Rezoning Transportation Analysis

Petition Number: 2020-002

Revision Log:	Date	Description
	02-18-2020	First Review
	03-20-2020	Second Review (WB)

SCHEMATIC SITE PLAN

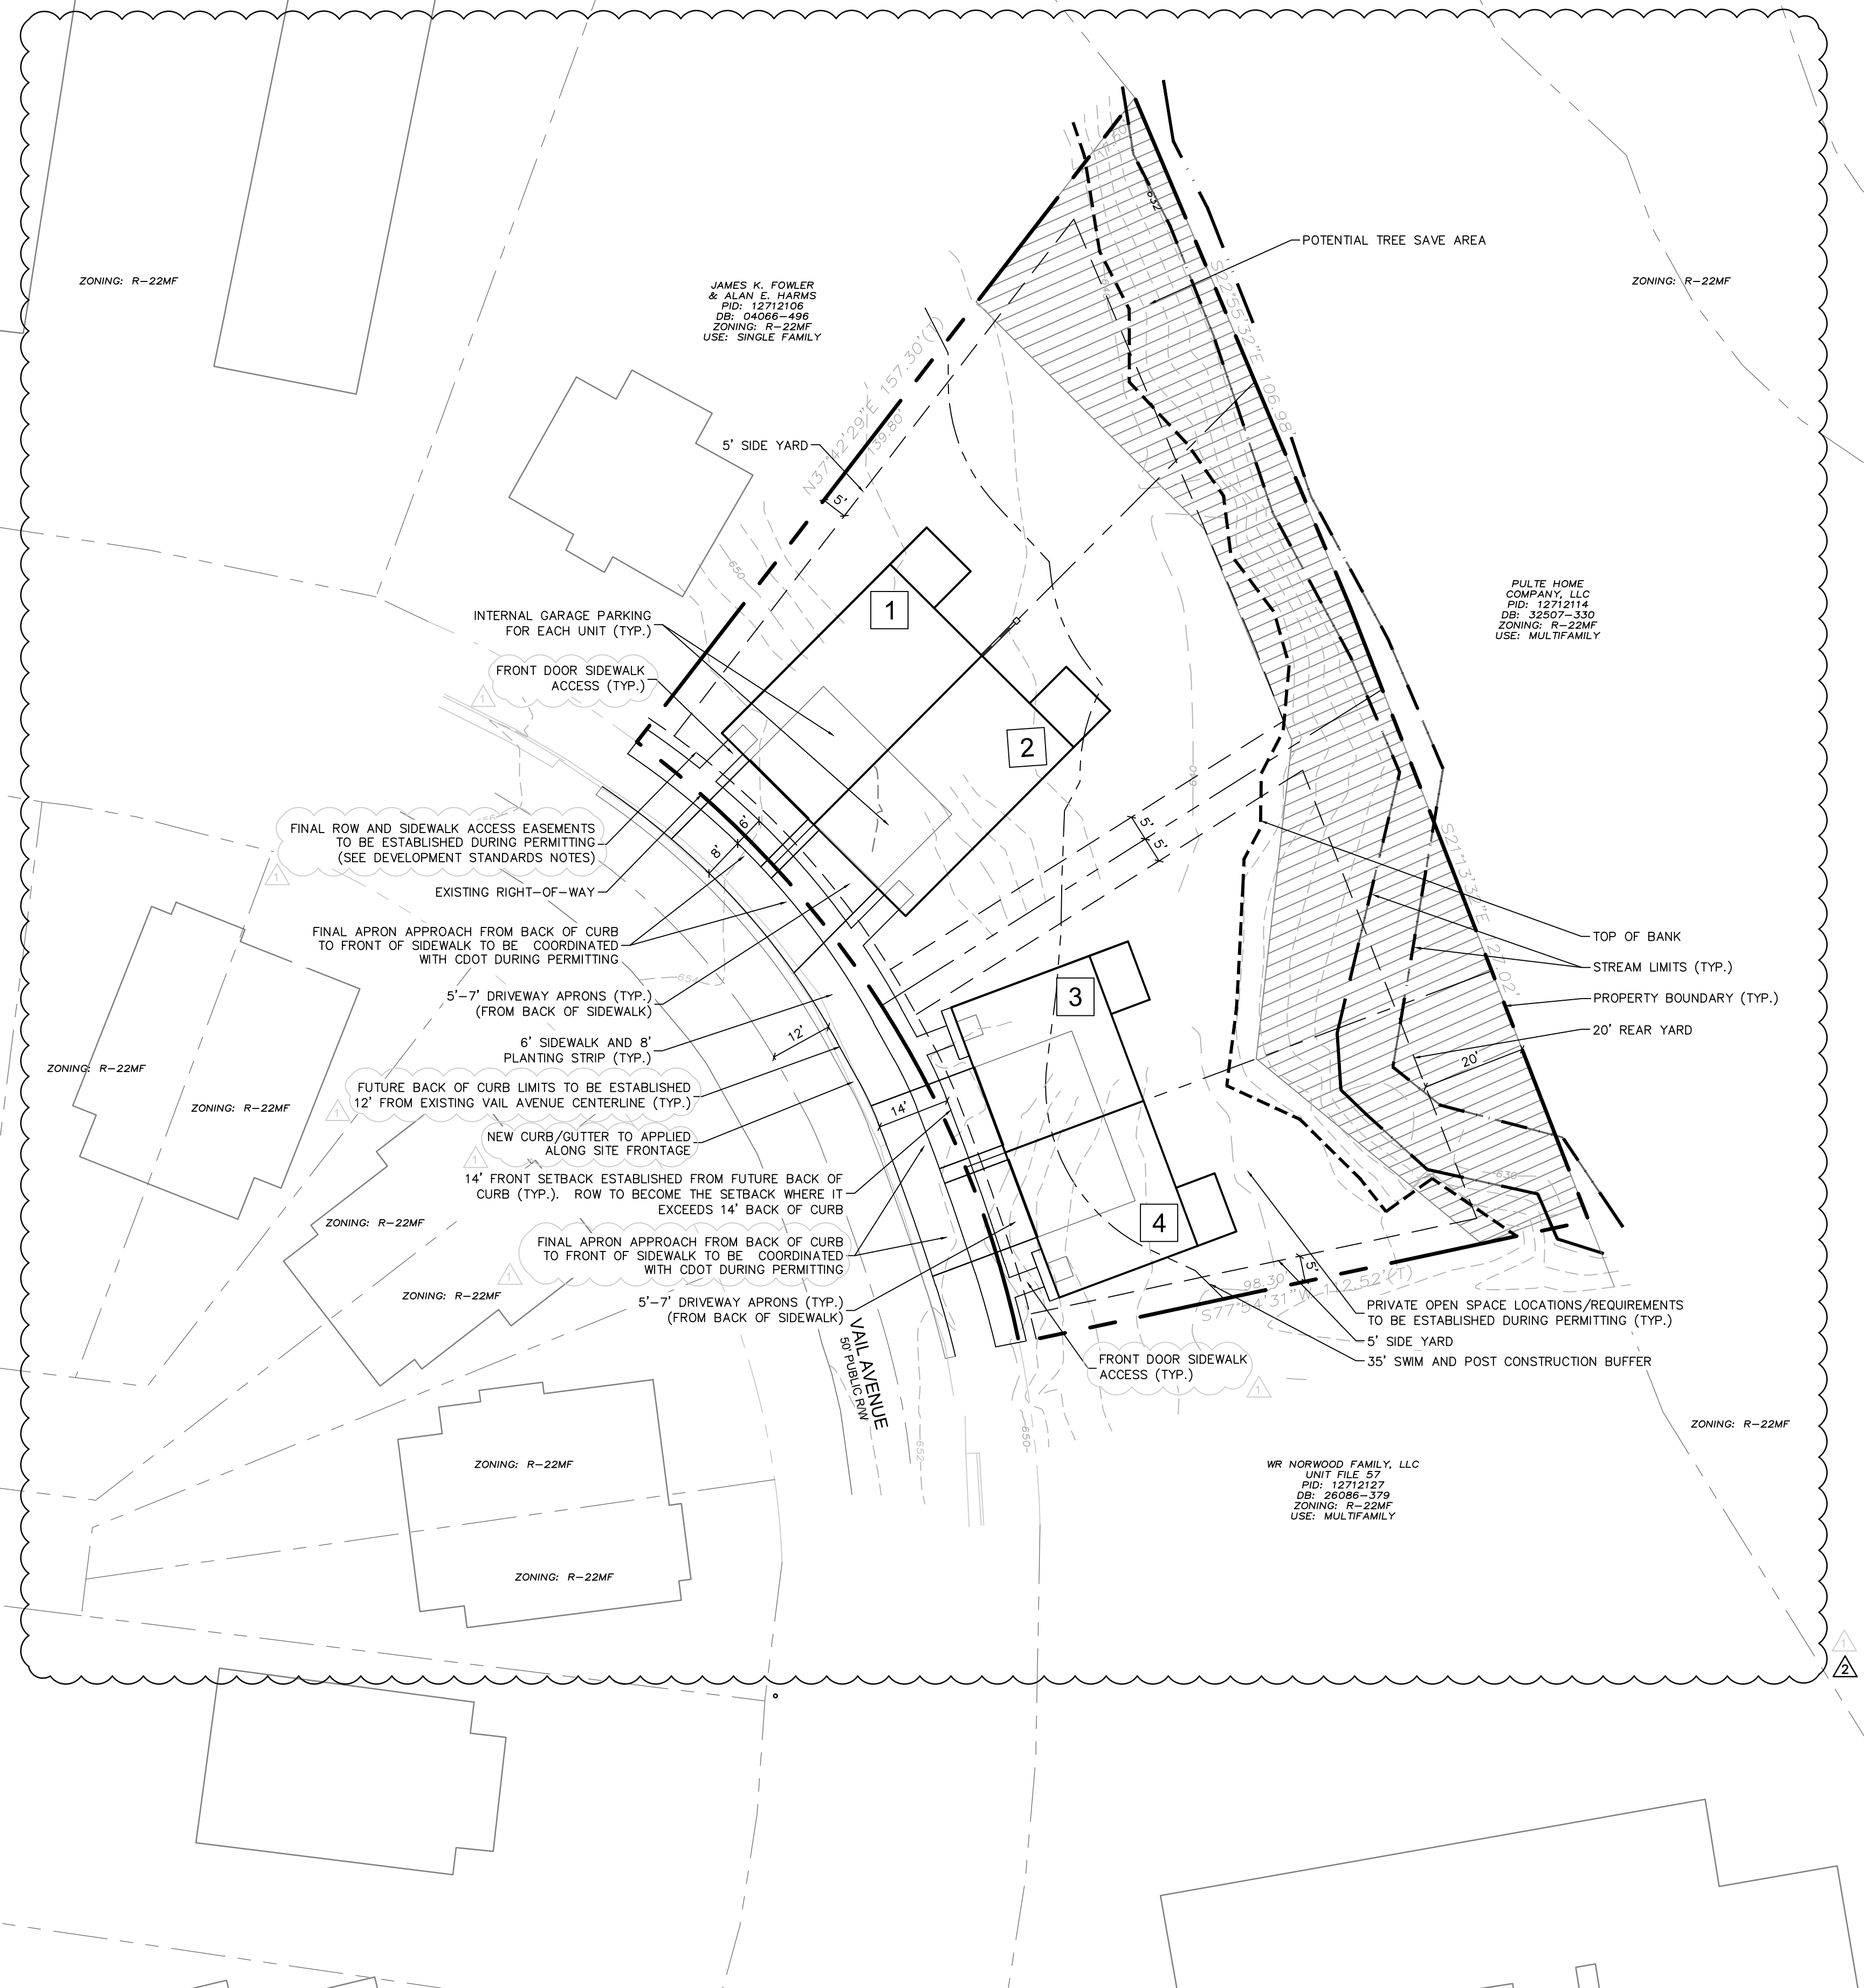
- ~~1. **Curbline** The proposed zoning district has a setback measured from back of the proposed future curbline.~~
 - ~~a. **Vail Avenue:** The future location of back of curb and gutter is 12' from centerline.~~

The site plan should show the curb and gutter labeled and dimensioned from the centerline for each road.

- ~~3. The petitioner should revise the site plan and conditional note(s) to commit to dedicate right-of-way from the road centerline to 2' behind the sidewalk for maintenance. The site plan should label and dimension the right-of-way from the road centerline.~~

- ~~4. The petitioner should revise the site plan and conditional note(s) to show connecting units sharing a single driveway to limit the disturbance of the sidewalk.~~

- ~~5. The petitioner should revise the site plan to add a note specifying all transportation improvements will be approved and constructed before the site's first building certificate of occupancy is issued. The petitioner may phase transportation improvements if said improvements and phasing are explicitly described in site plan notes.~~
